SUBJECT: Response to “**PUDSP-19-004 – Midtown Collection at Hannah Ridge First Submittal**”, dated April 6, 2019

MIDTOWN COLLECTION AT HANNAH RIDGE
PUD DEVELOPMENT PLAN & PRELIM. PLAN
PRELIMINARY GRADING & UTILITIES PLAN

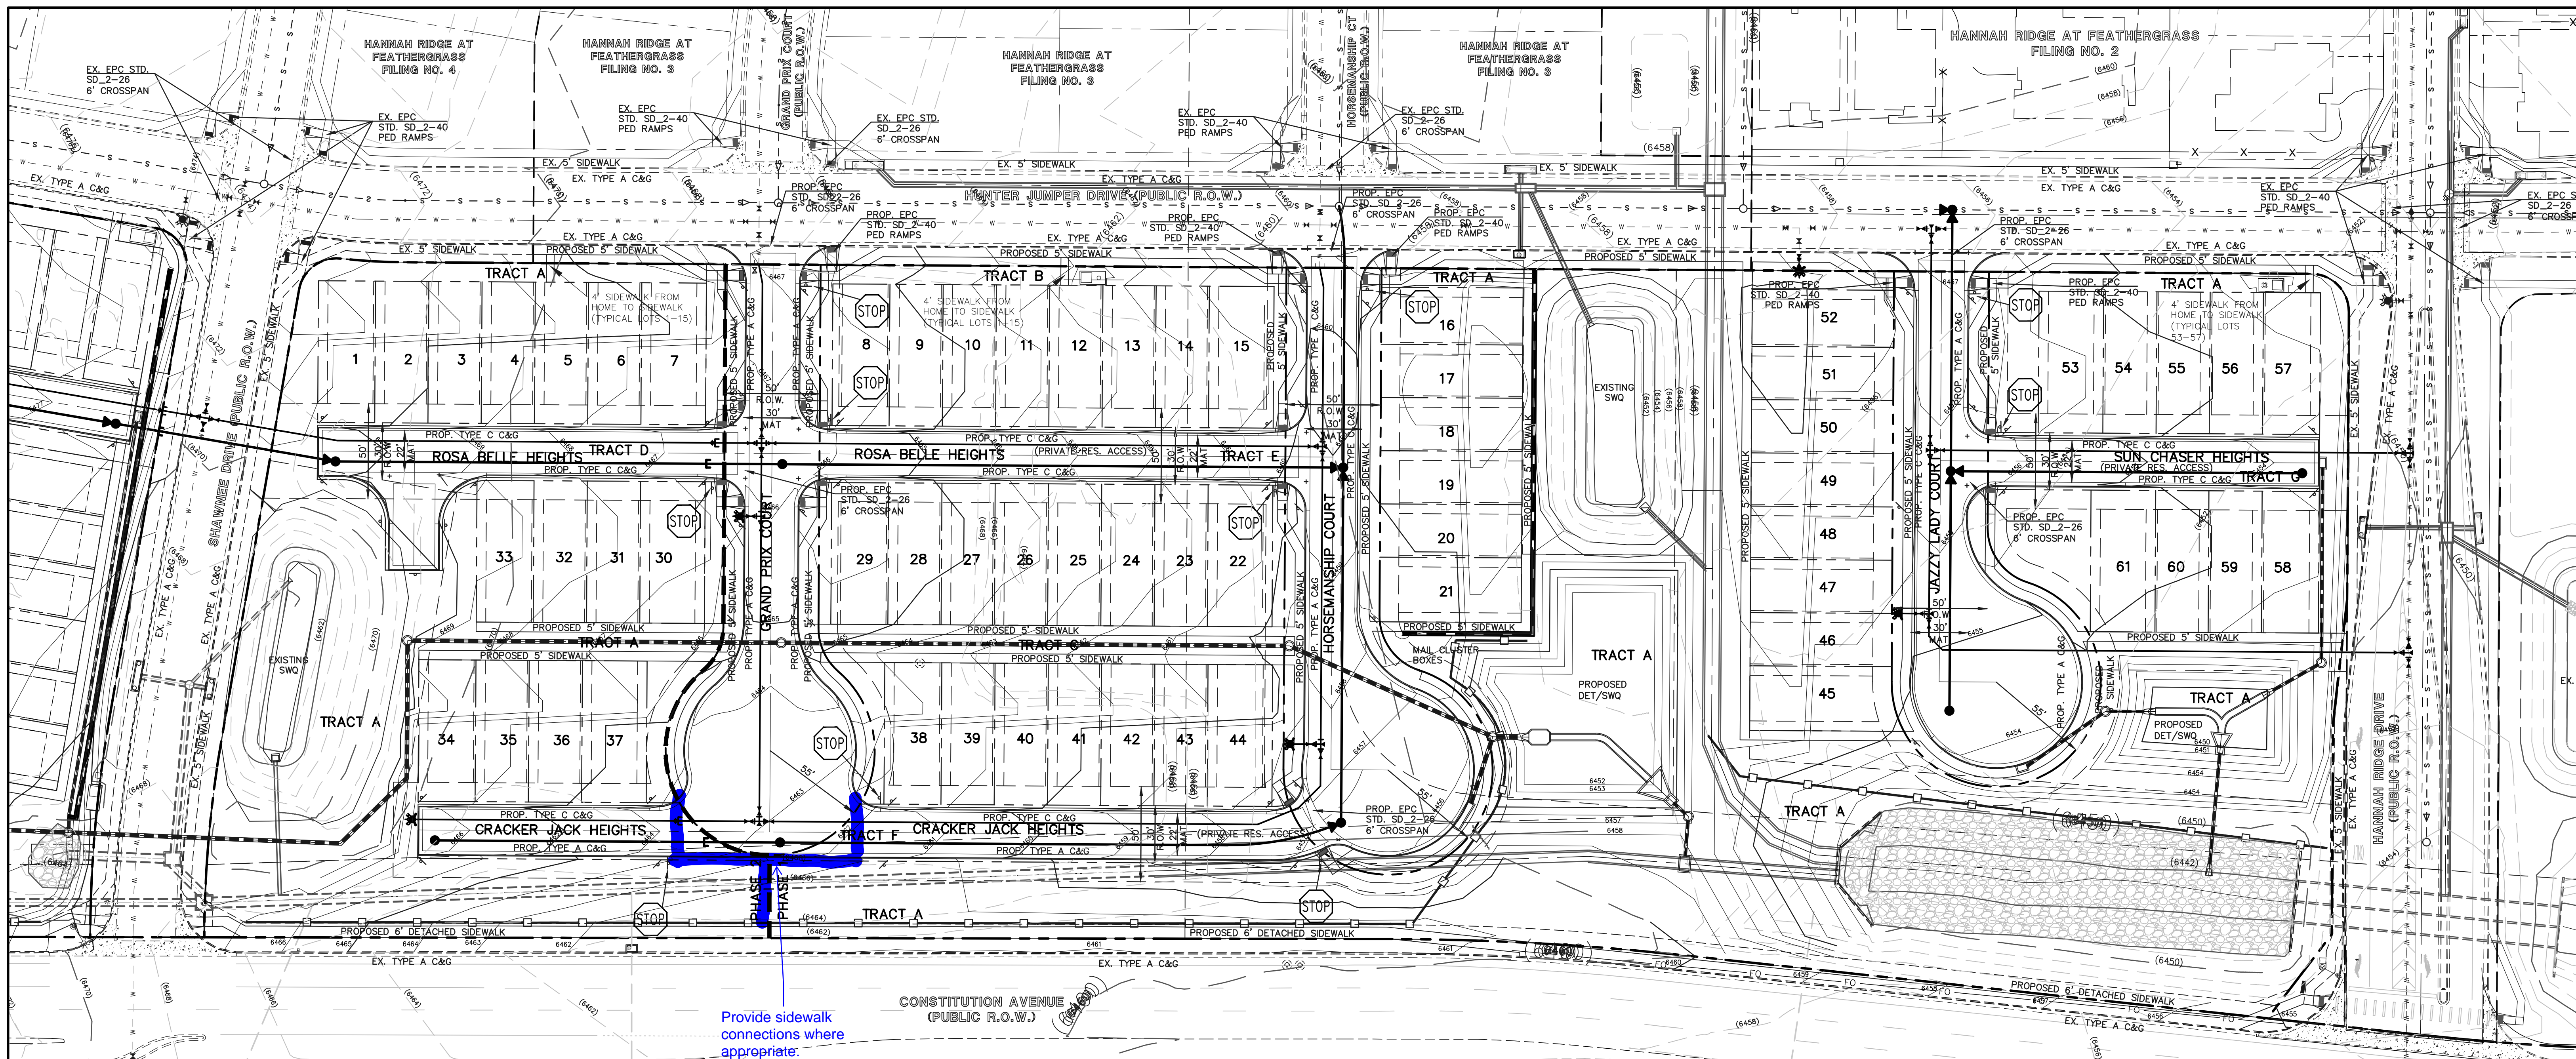
2. Provide sidewalk connections as appropriate to the proposed sidewalk along Constitution Avenue (see redlines).

**RESPONSE: Added as requested.**

MIDTOWN COLLECTION AT HANNAH RIDGE
 FILING NO. 1
 DEVELOPED CONDITIONS DRAINAGE MAP

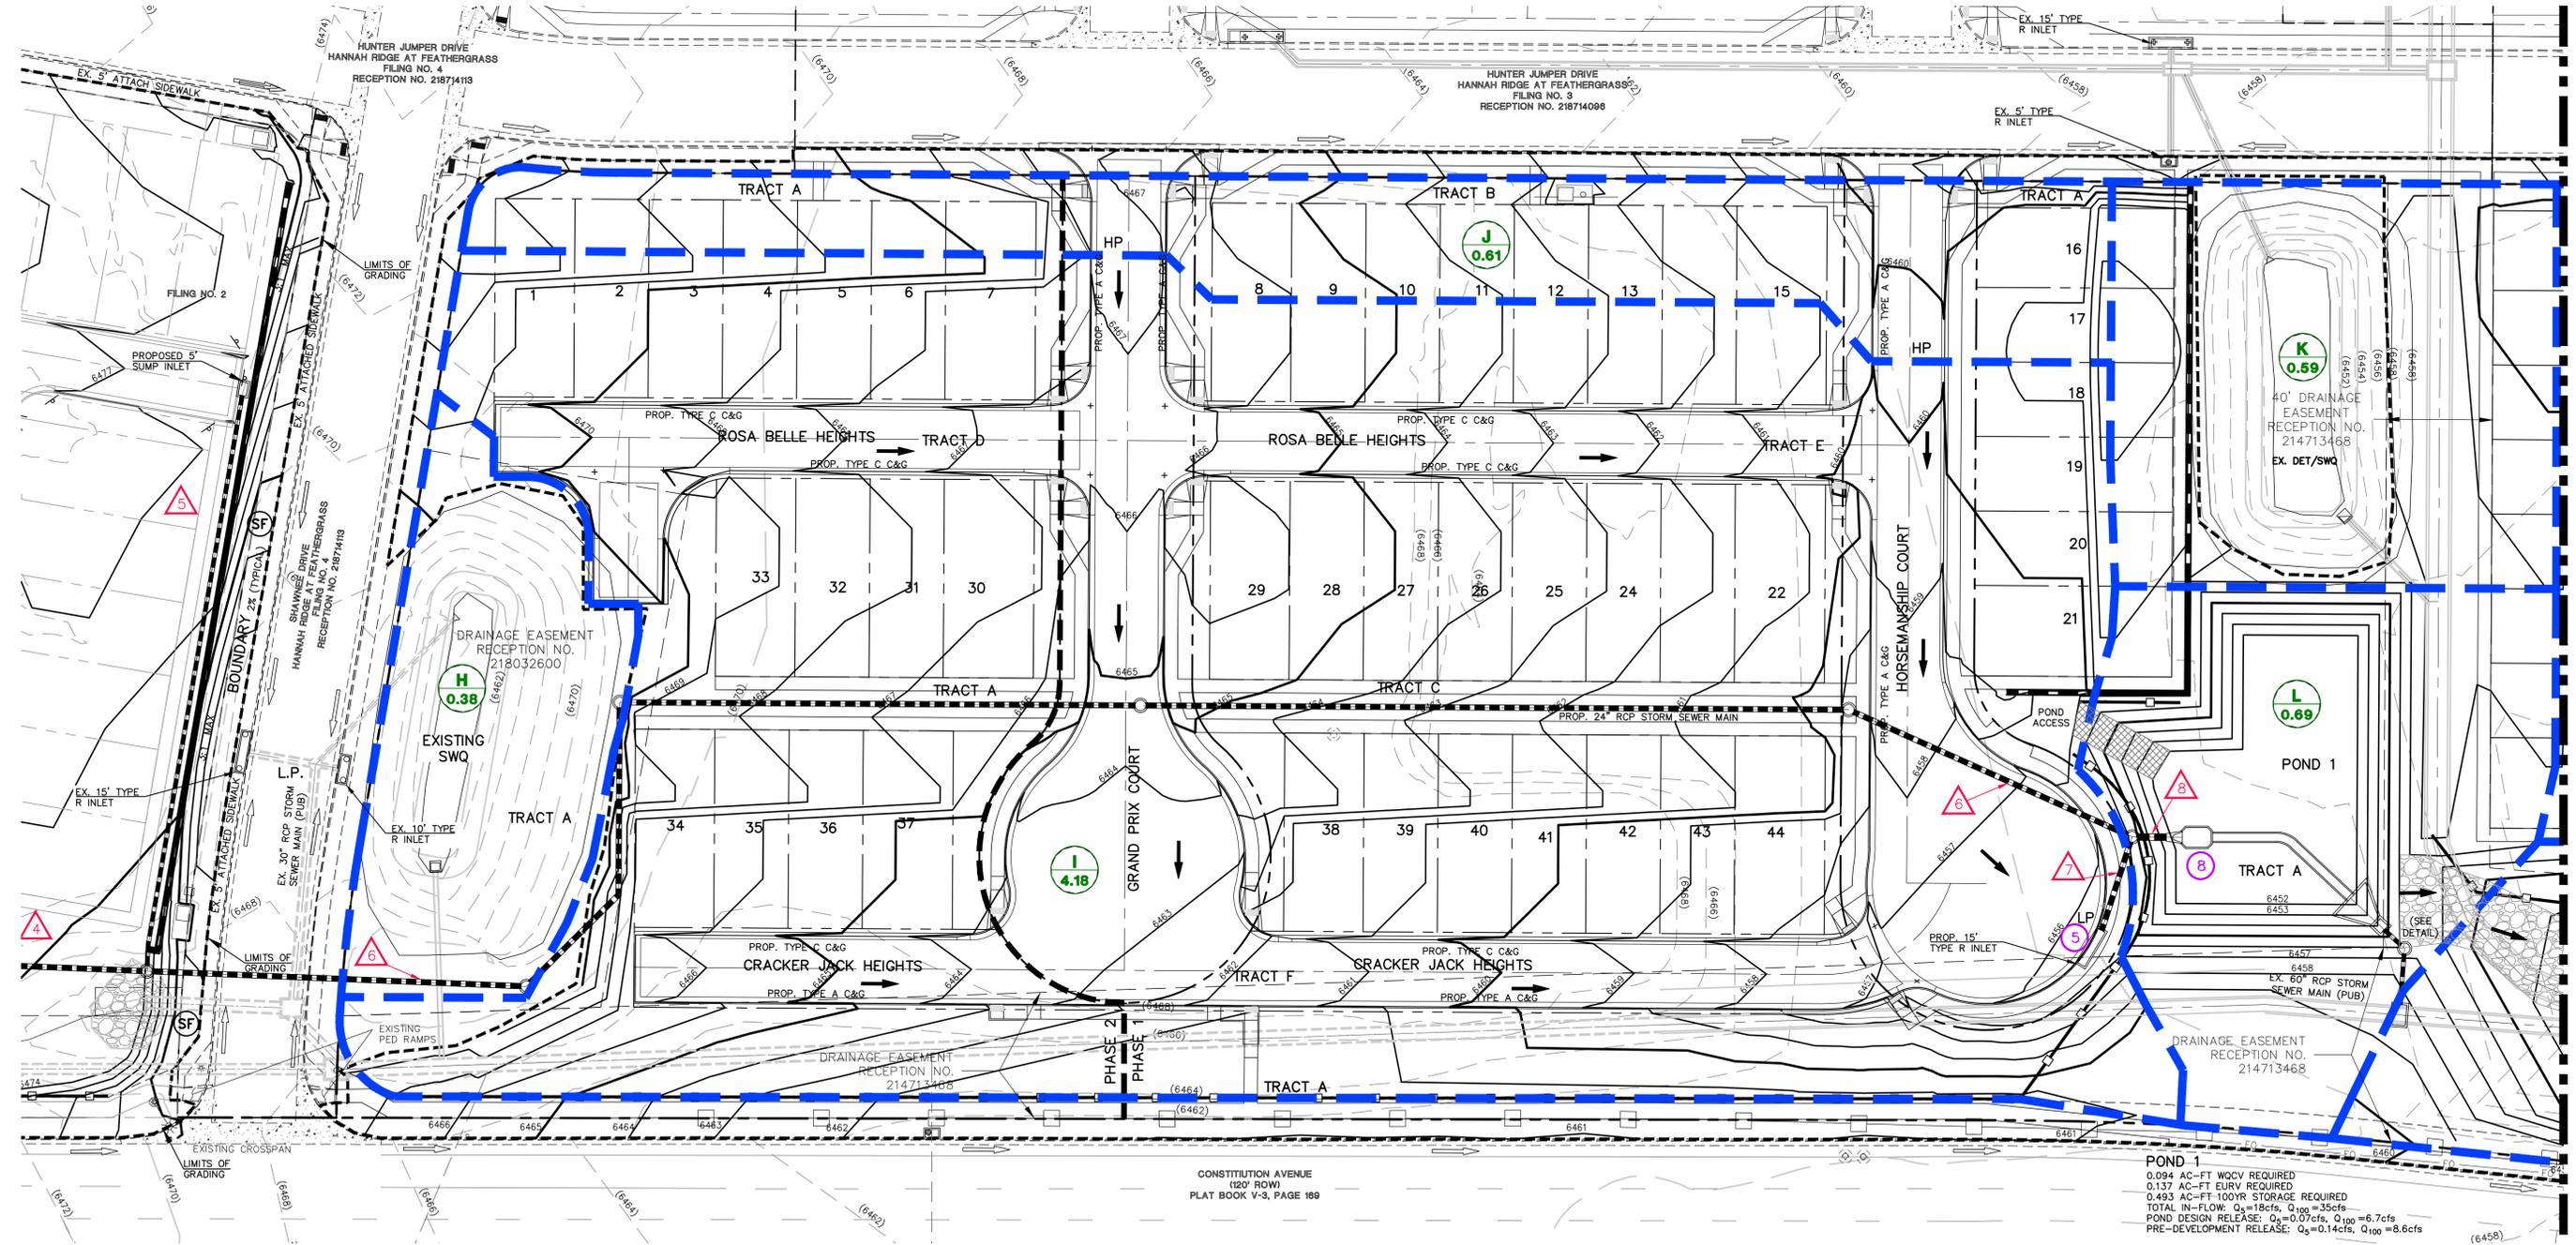
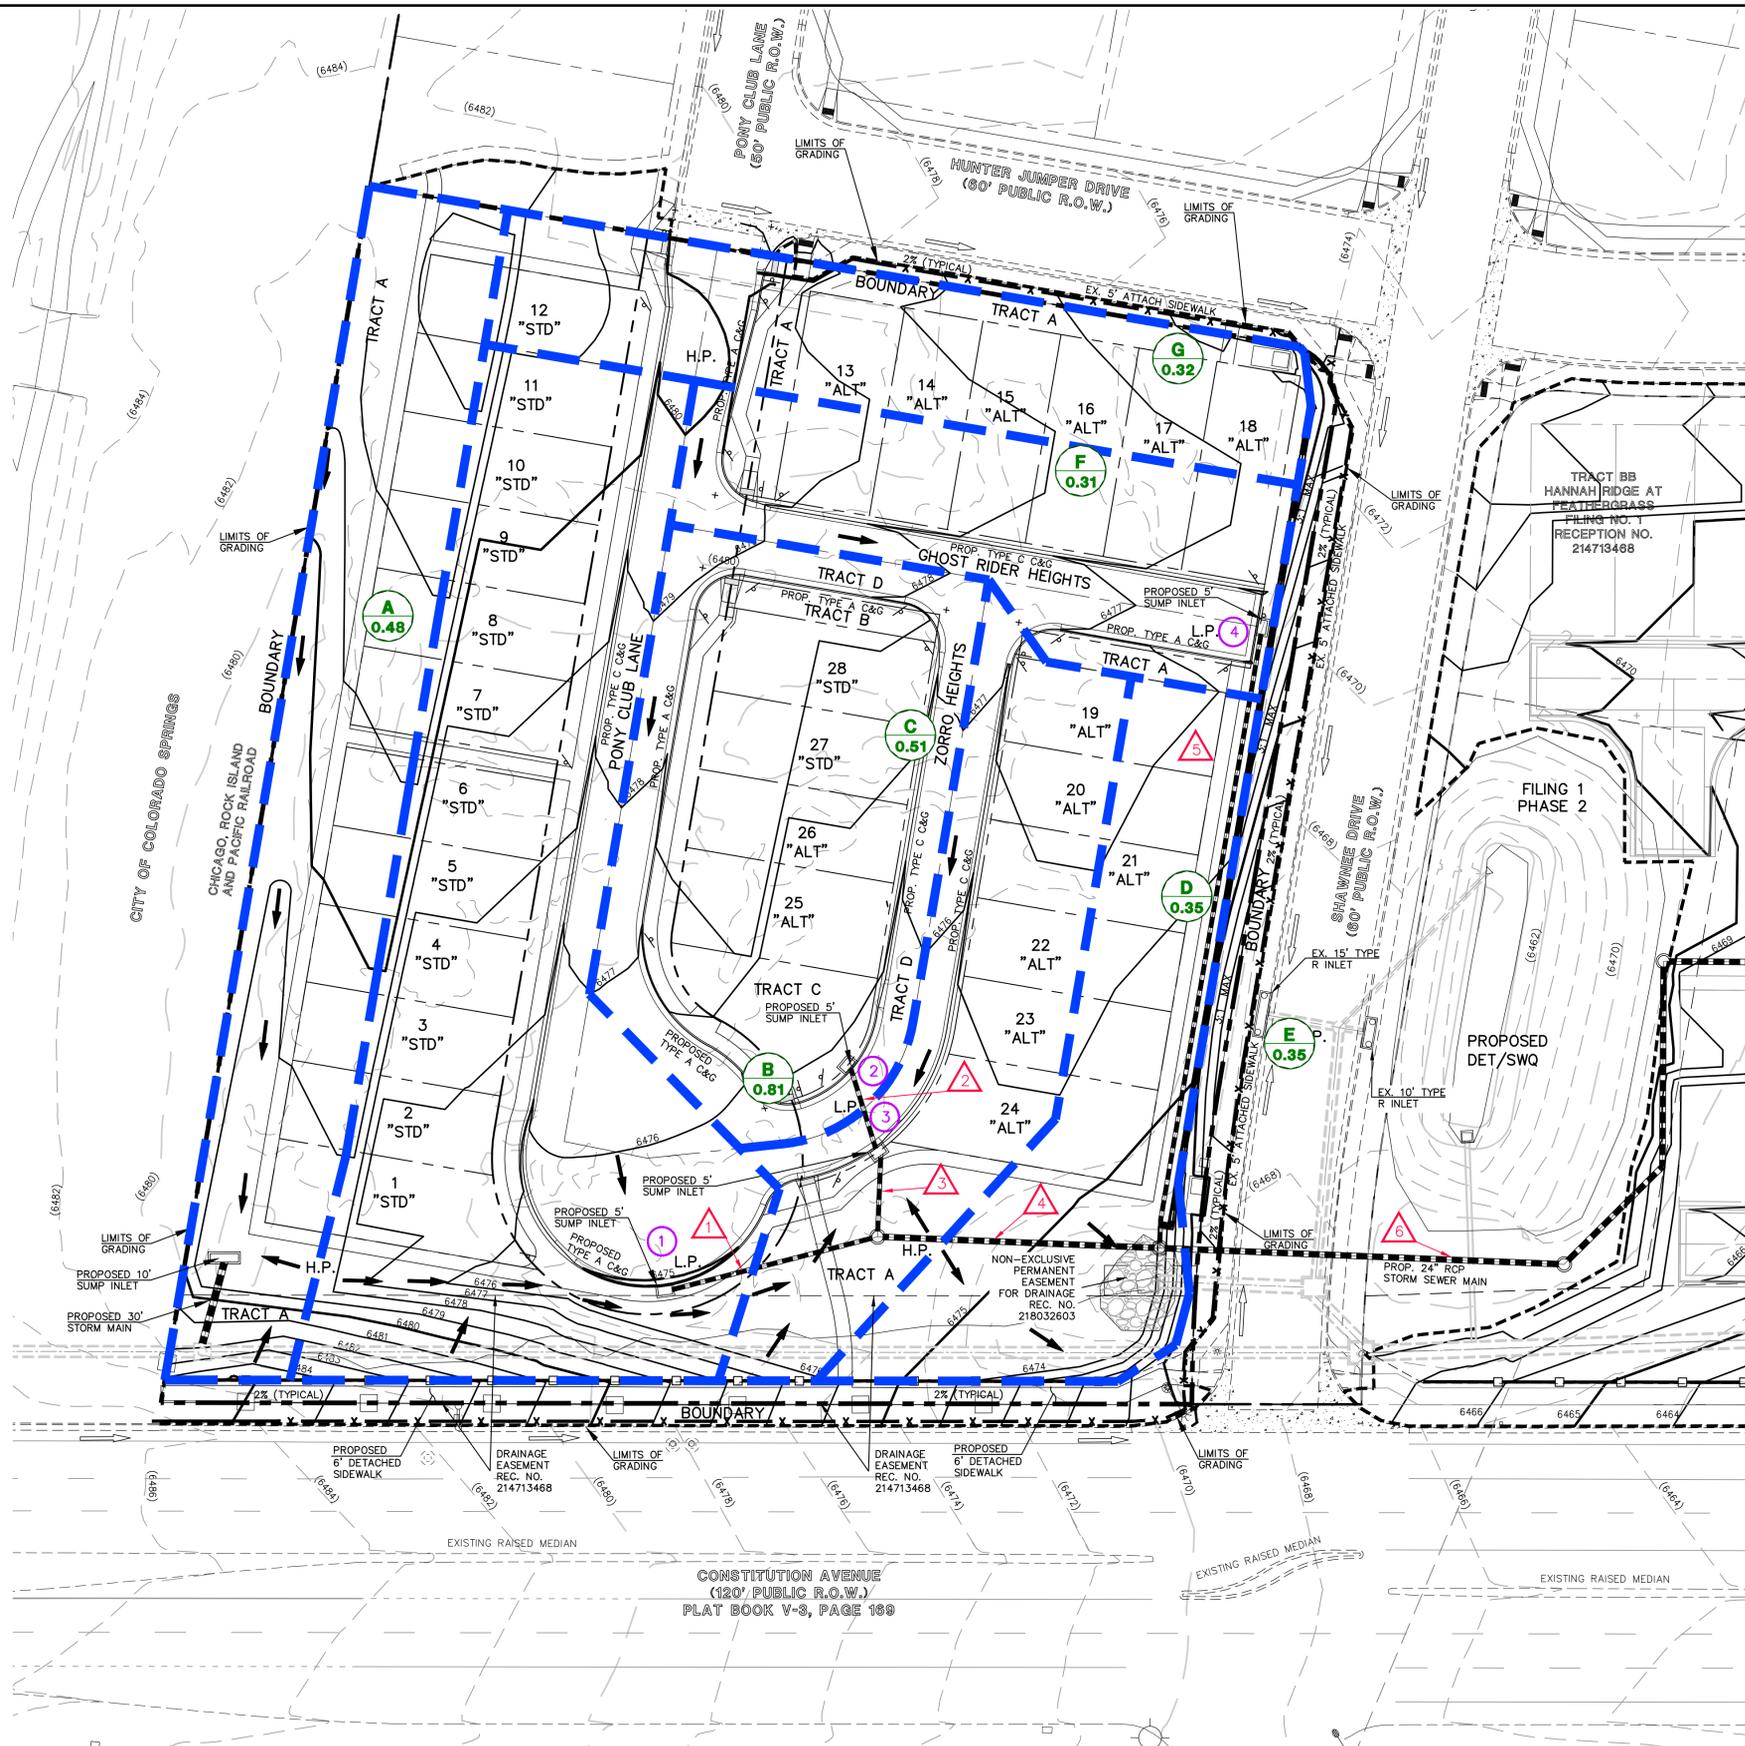
1. Clearly show access roads for ponds and channels on the drainage plans. Provide internal access to the ponds and ensure no conflicts with landscaping plan.

**RESPONSE: Please see revised plan.**
